CITY OF PORTLAND BUILDING PERMIT

Job ID: 2011-12-2992-ALTCOMM

has permission to Renovate /Add Passage through to combine both restaurants, new exterior steps, bathrooms & kitchen provided that the person or persons, firm or corporation accepting this permit shall comply with all of the provisions of the Statues of Maine and of the Ordinances of the City of Portland regulating the construction, maintenance and use of the buildings and structures, and of the application on file in the department.

Jeanie Bourke - Re: Fw: Vignola Deck plan

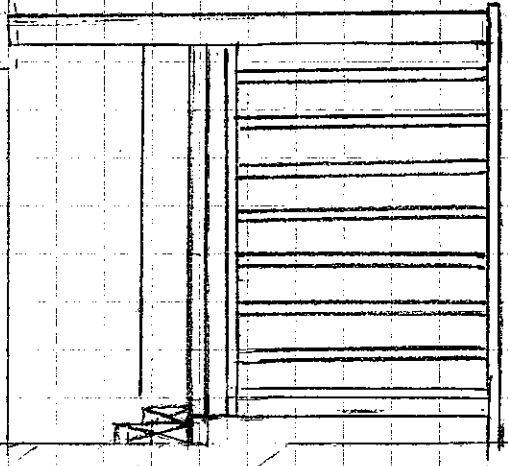
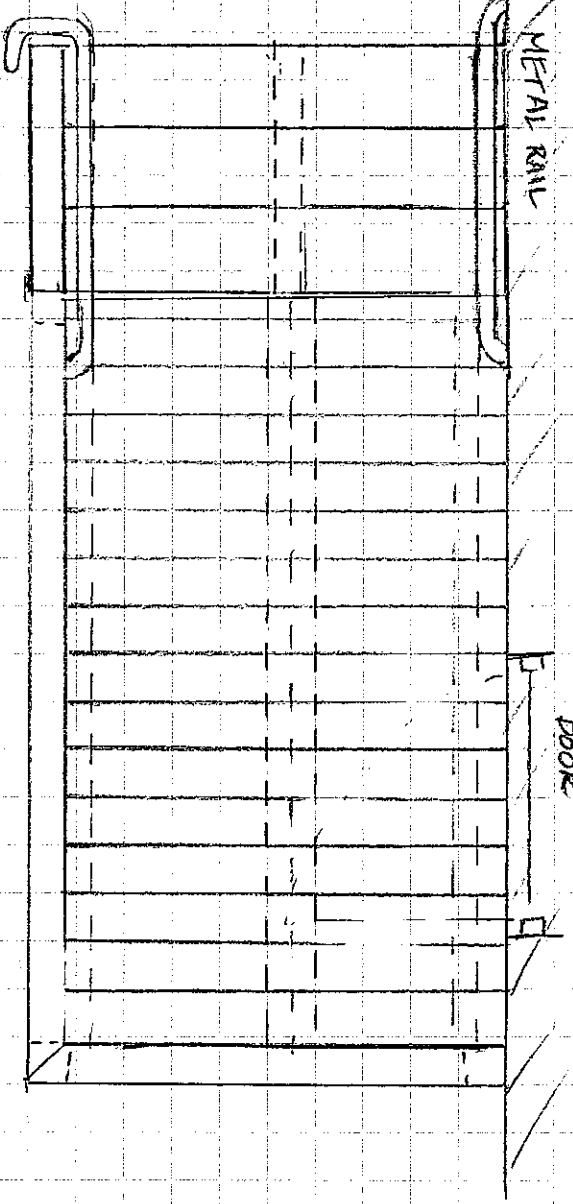
Please make note that a "bullnose" or nosing projection" is not allowed on commercial stairs. The rise to run profile needs to be either a 90 degree flush detail or a slant or angled back cut from the leading edge of the tread as specified in Sec. 1009.4.5.

Yes Aaron, I will print this email and note a condition on the approval.

I will not bullnose the stair tread and will use the typical back cut riser as noted in your Email. Please let me know if this Email is sufficient or if you would like me to revise the sketch and resubmit
